Regulatory, Planning and Assessment.GMansfield/MBisson
Reference: SD2020/0005.02
Phone: 02 4974 2000

1 July 2021

**45 HONEYSUCKLE DRIVE NEWCASTLE - MIXED USE DEVELOPMENT
(SSD-9827-MOD-2)**

Basement 01
SCALE 1:200 @ A1

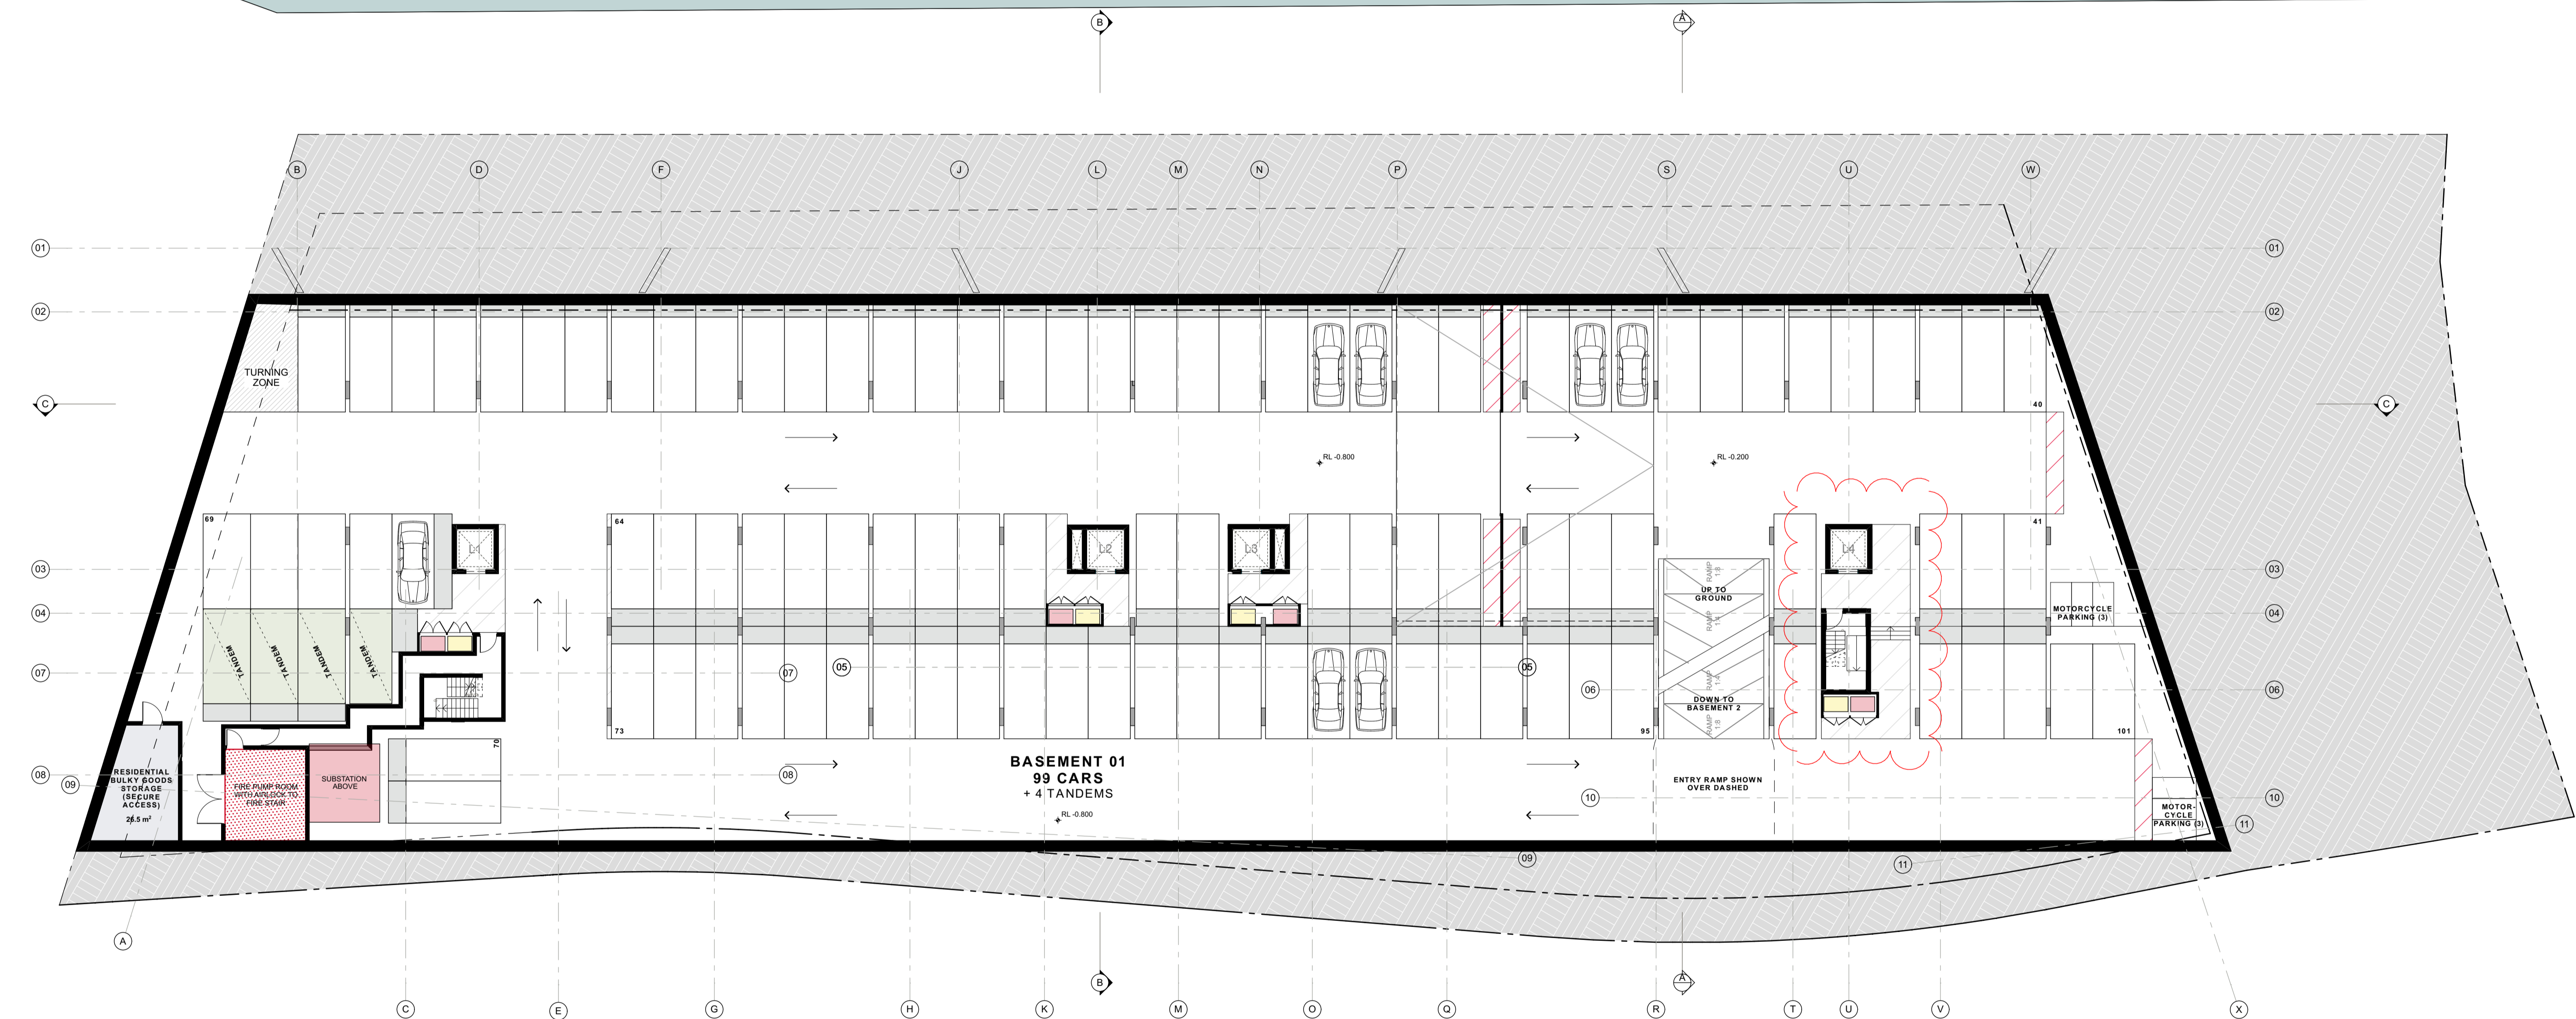
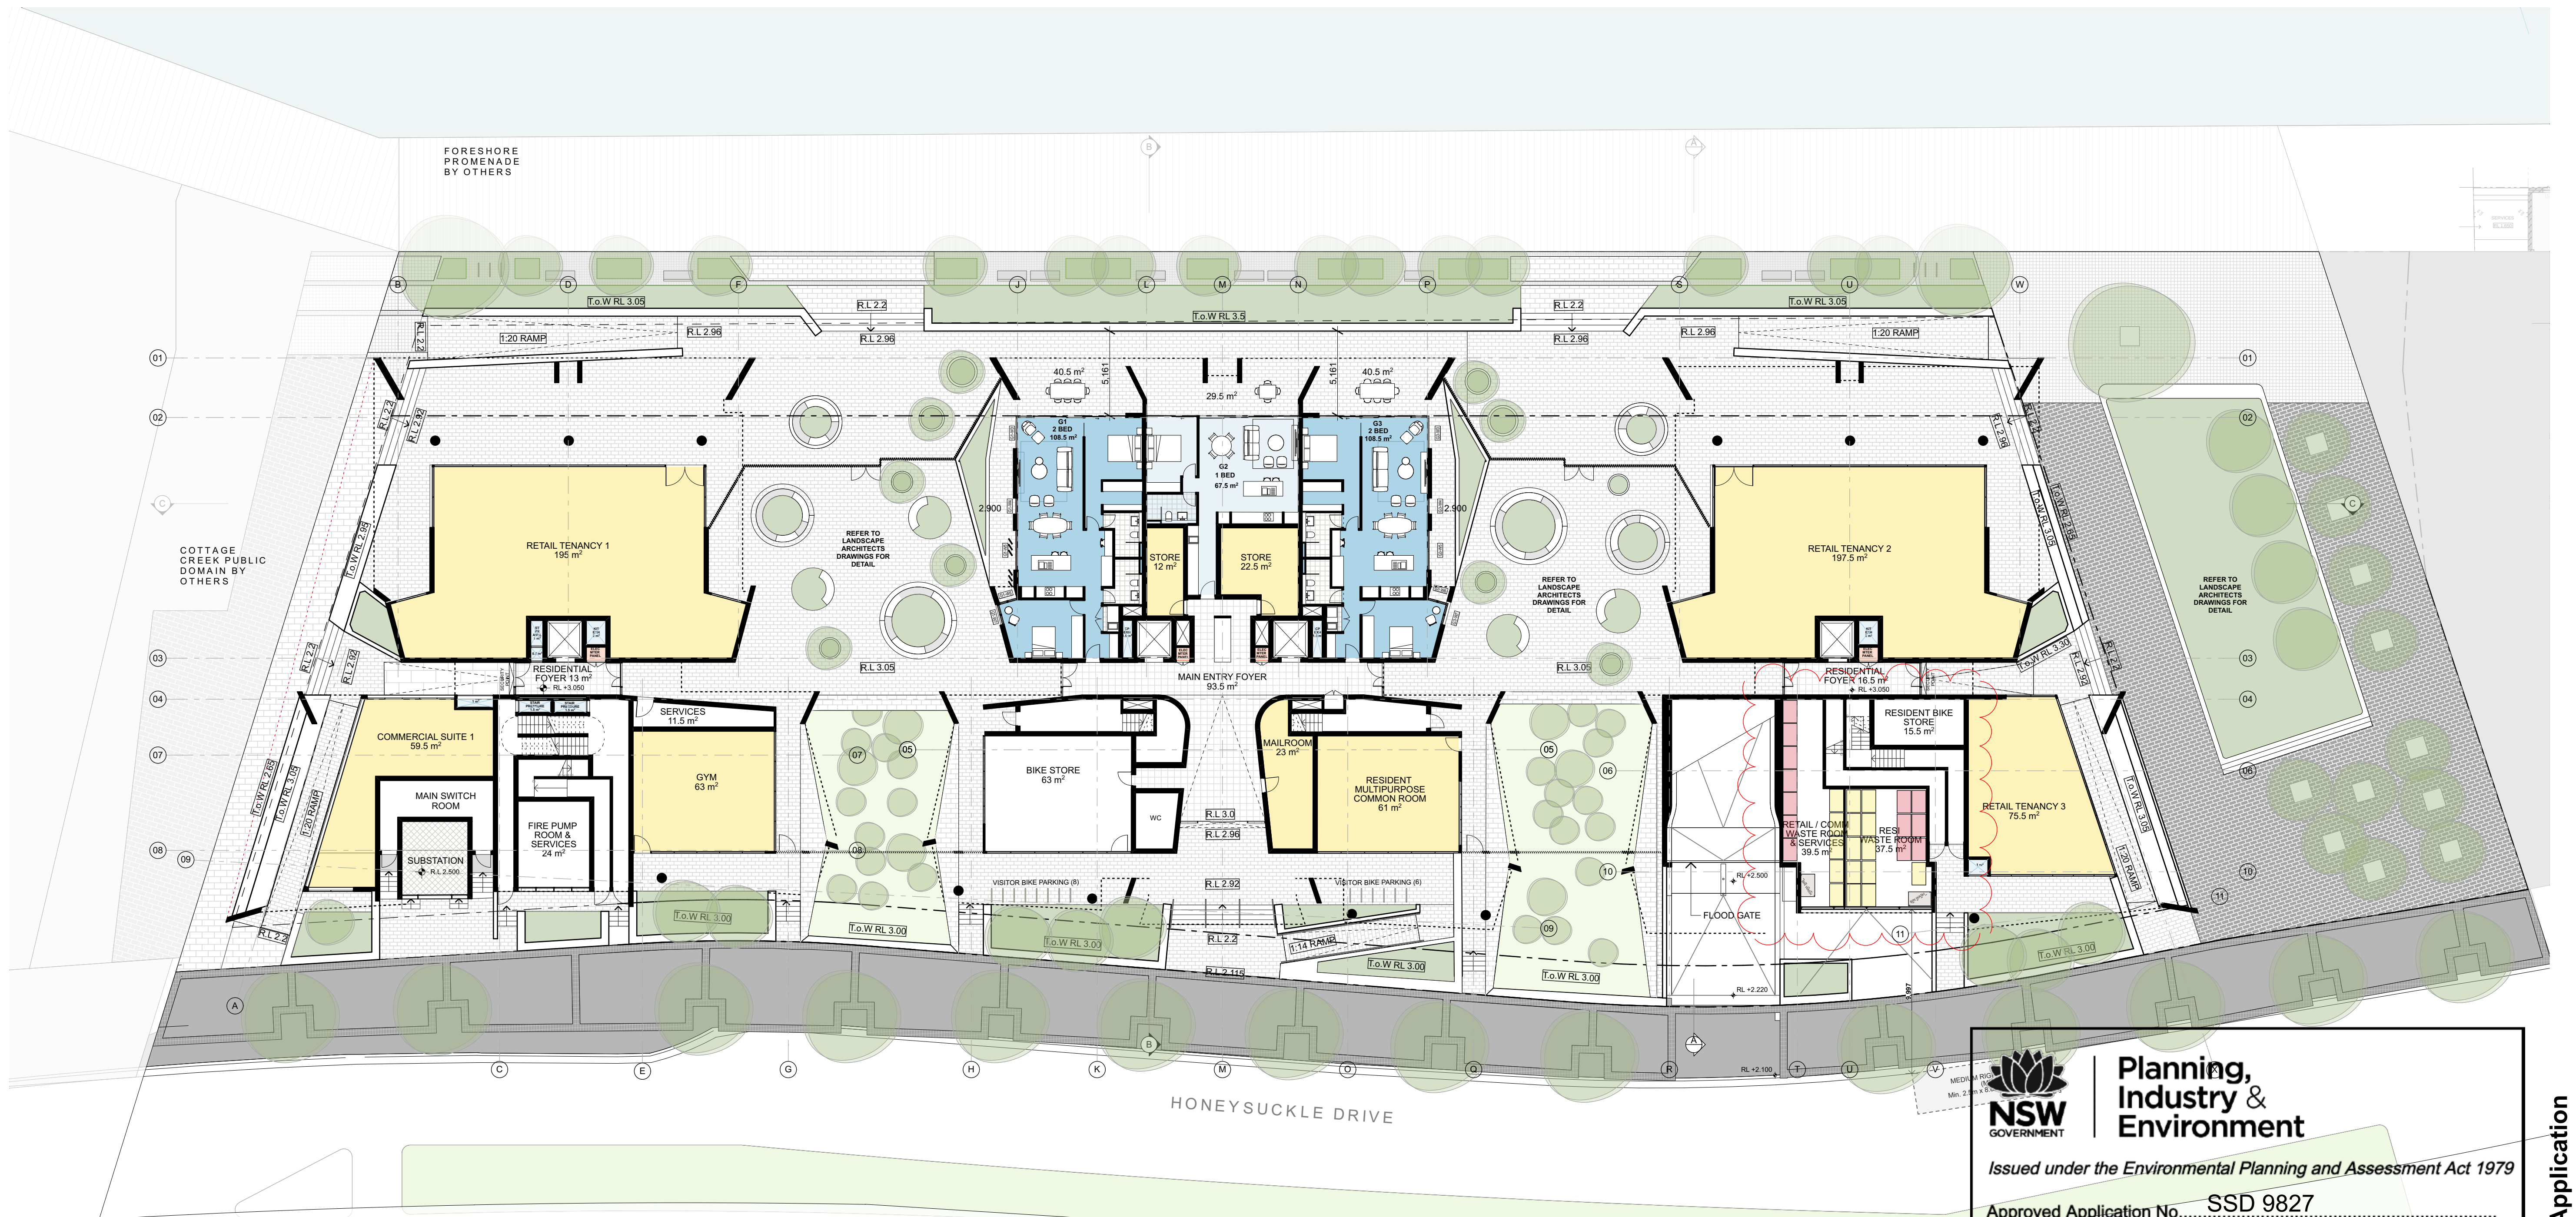
SSD-9827-Mod-2 seeks a further 41 parking spaces in the number of residential parking over what is currently approved, such being in total 75 spaces in excess of the parking rates of NDCP 2012 based on the revised apartment mix. The applicant has attempted to justify this increase utilising market demand and the nature of car ownership within existing unit developments, submitting a Parking Demand Assessment prepared by SLR Consulting Australia Pty Ltd ('SLR').

It is confirmed that CN has been prepared to reduce the visitor parking for developments in the City Centre based on the availability of on-street time restricted parking. On this basis the reduction in visitor parking from 23 to 10 spaces would be supported. The residential visitor parking spaces should be located in close proximity to lifts and be easily accessible to facilitate utilisation of these bays.
